Recommendation Report for Planning Permission

REF NO: BR/201/21/PL

LOCATION: Ravenna
Richmond Avenue West
Bognor Regis
PO21 2YG

PROPOSAL: Erection of a new building comprising of 3 No apartments (2 No 2 bed units & 1 No 1 bed unit), including alterations to the fenestration of the existing building (resubmission following BR/176/20/PL). This site is in CIL Zone 4 (Zero Rated) as flats.

| DRAWING TITLE<br>Existing House<br>Ground Floor Plan as Proposed          |         |           |                       | COMPUTER FILE NAME DWG.DWG          |                       |          |

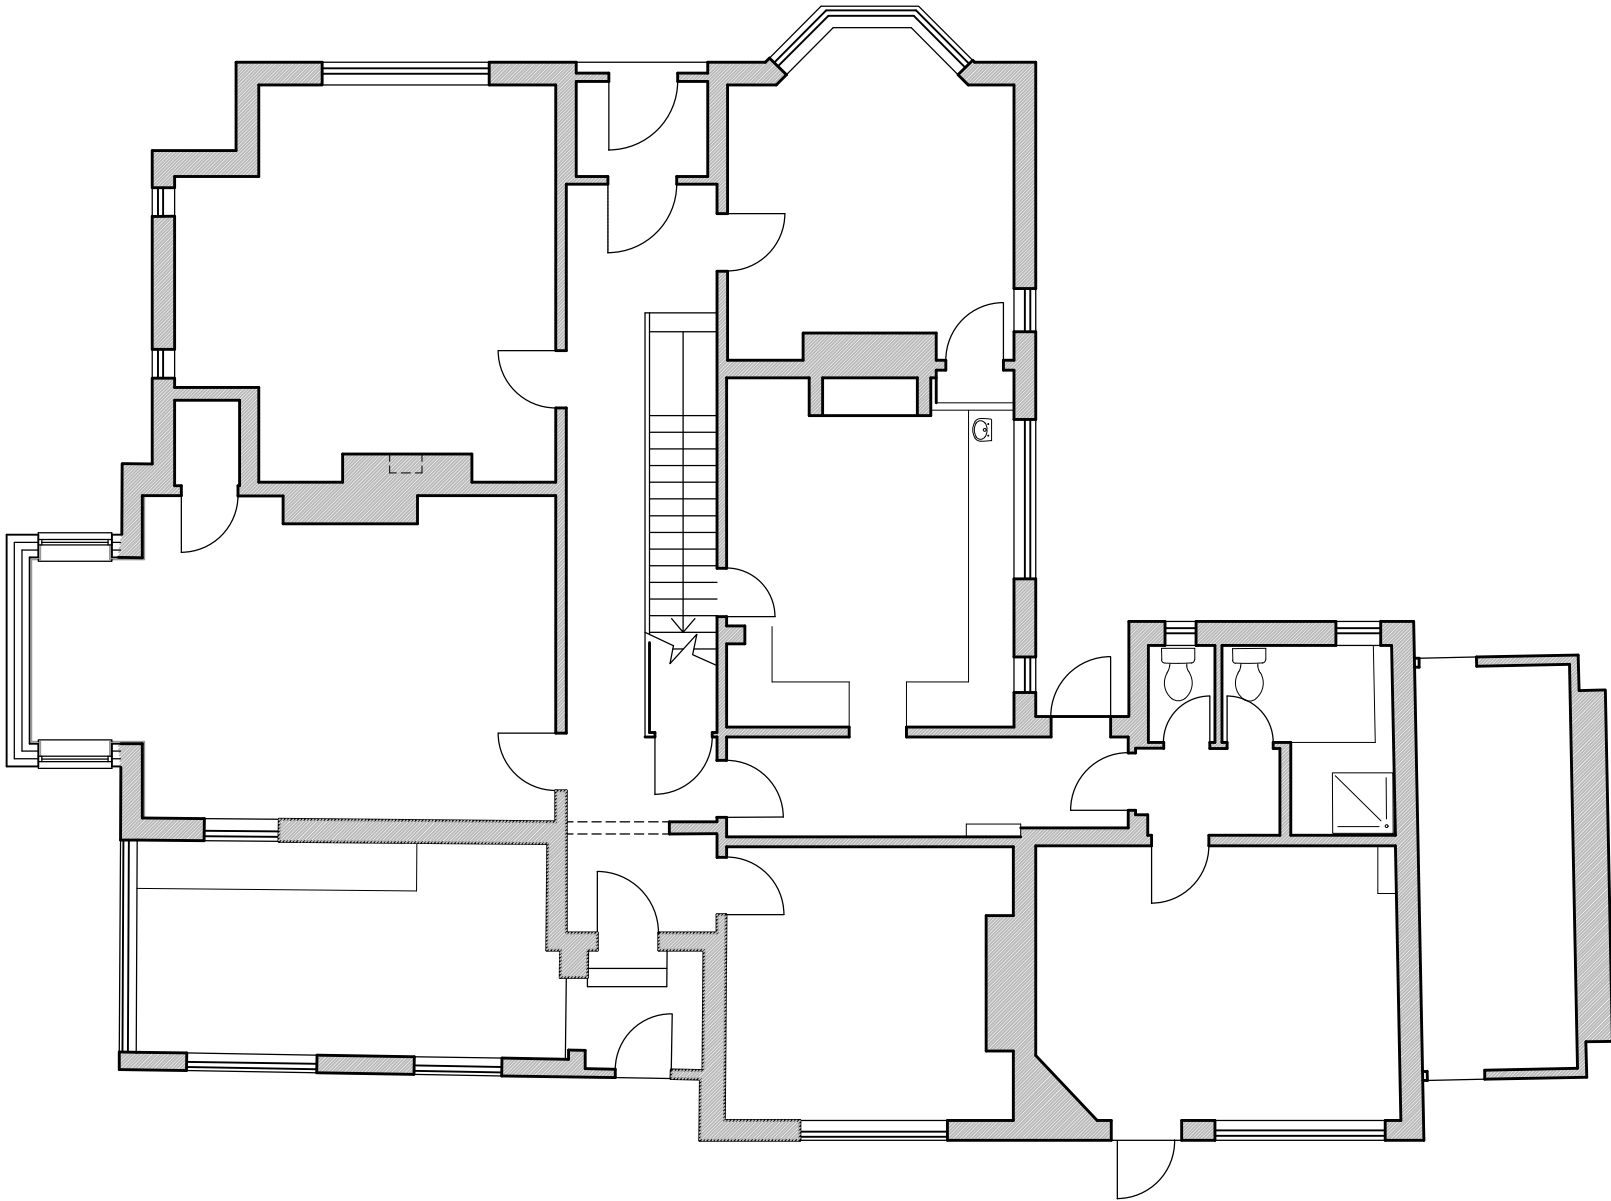
The structure given its proximity to Ravenna House has an overbearing impact on residents of this property resulting in significant loss of sunlight and their outlook would be blocked by the building and a wall which would replace existing large windows to give a way the proposed development.

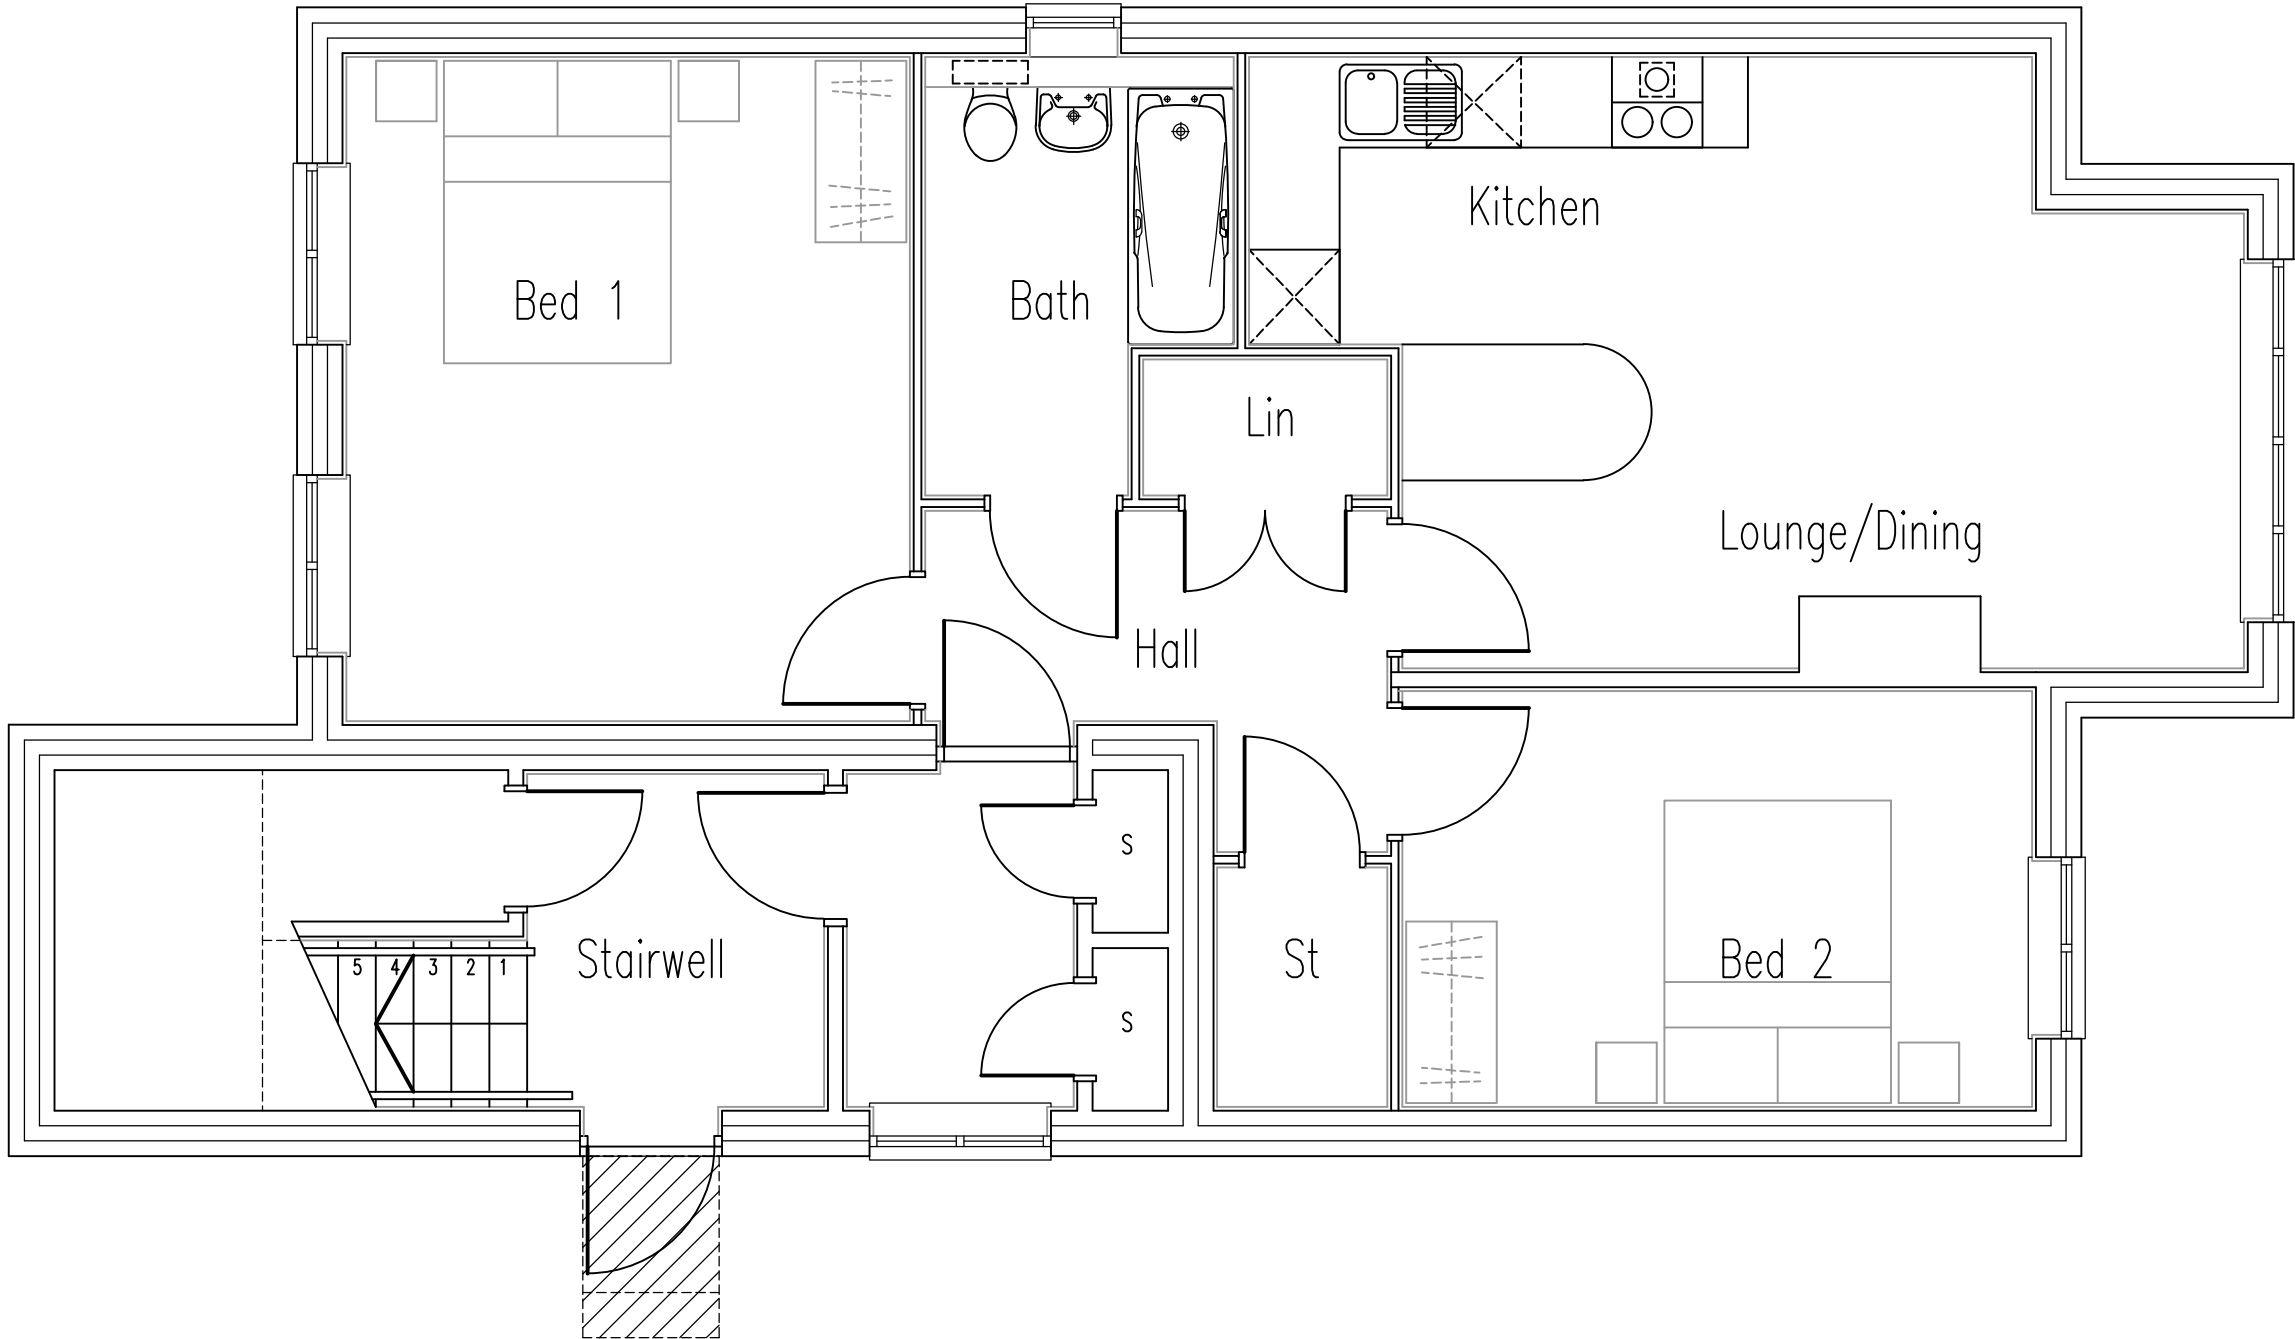
The stairwell windows at the first/second floor level facing the private area of Canberra Court to the east has been removed, however there are bedroom windows proposed on the east elevation at the first and second floor level with a separation distance of approximately 9m from this private area that results in unacceptable overlooking and loss of privacy of Canberra Court's residents.

The submitted drawings do not show an area dedicated to residential outdoor amenity, on the contrary the site would detract from the open space available for the existing HMO for 18 persons. The proposal results in overdevelopment of the site with no proper outdoor amenity space provided for and existing 18 and prospective 6 residents.
